PLANNING CONSULTATION RESPONSE

Application No	2026/0418
Proposal	Discharge of conditions 3 (Biodiversity Gain Plan) and 4 (landscaping/trees) of application 2025/0956: Construction of single storey sectional concrete building for use as new storage (Amended Description).
Address	3A Queens Drive, Old Town, Barnsley, S75 2QJ
Date of Consultation Reply	16/06/2025
Consultee	Katie Lawrence, Planning Ecologist

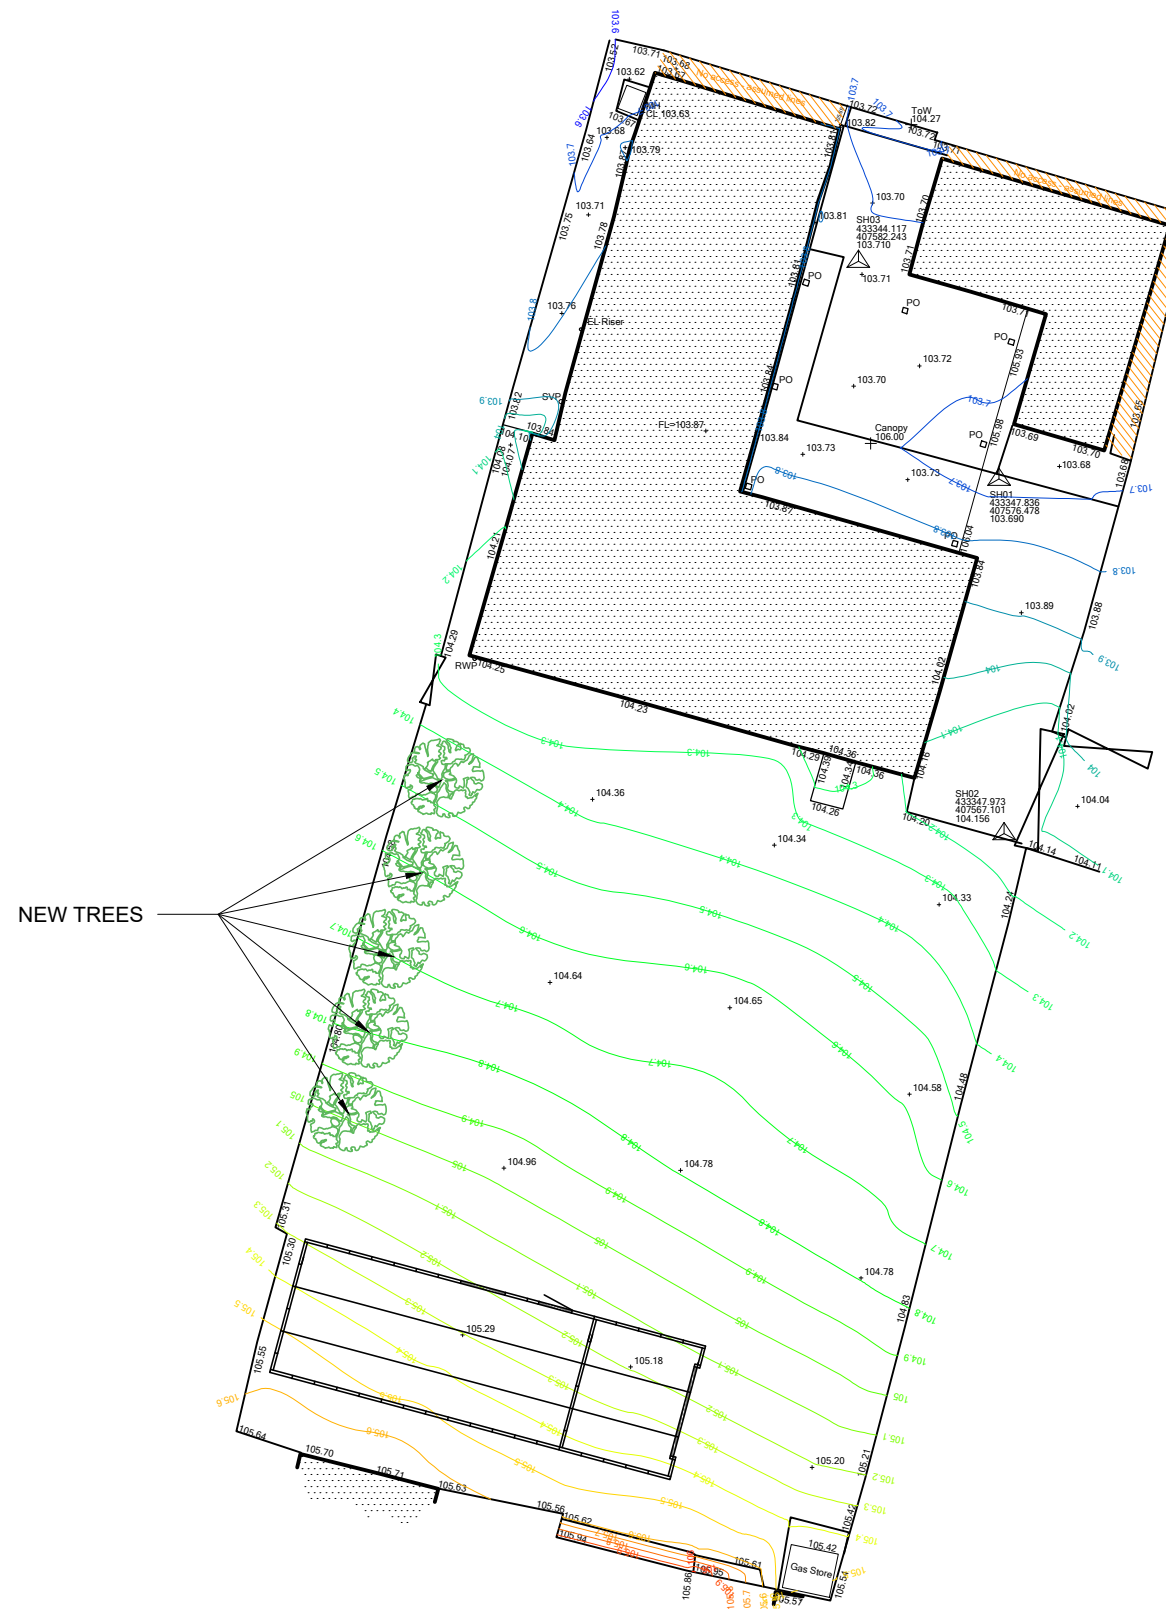
- The landscape proposals plan submitted indicates the location of the proposed five small trees and also details on the preparation of the site prior to planting and maintenance. This is considered satisfactory.

I recommend discharge of condition 4.
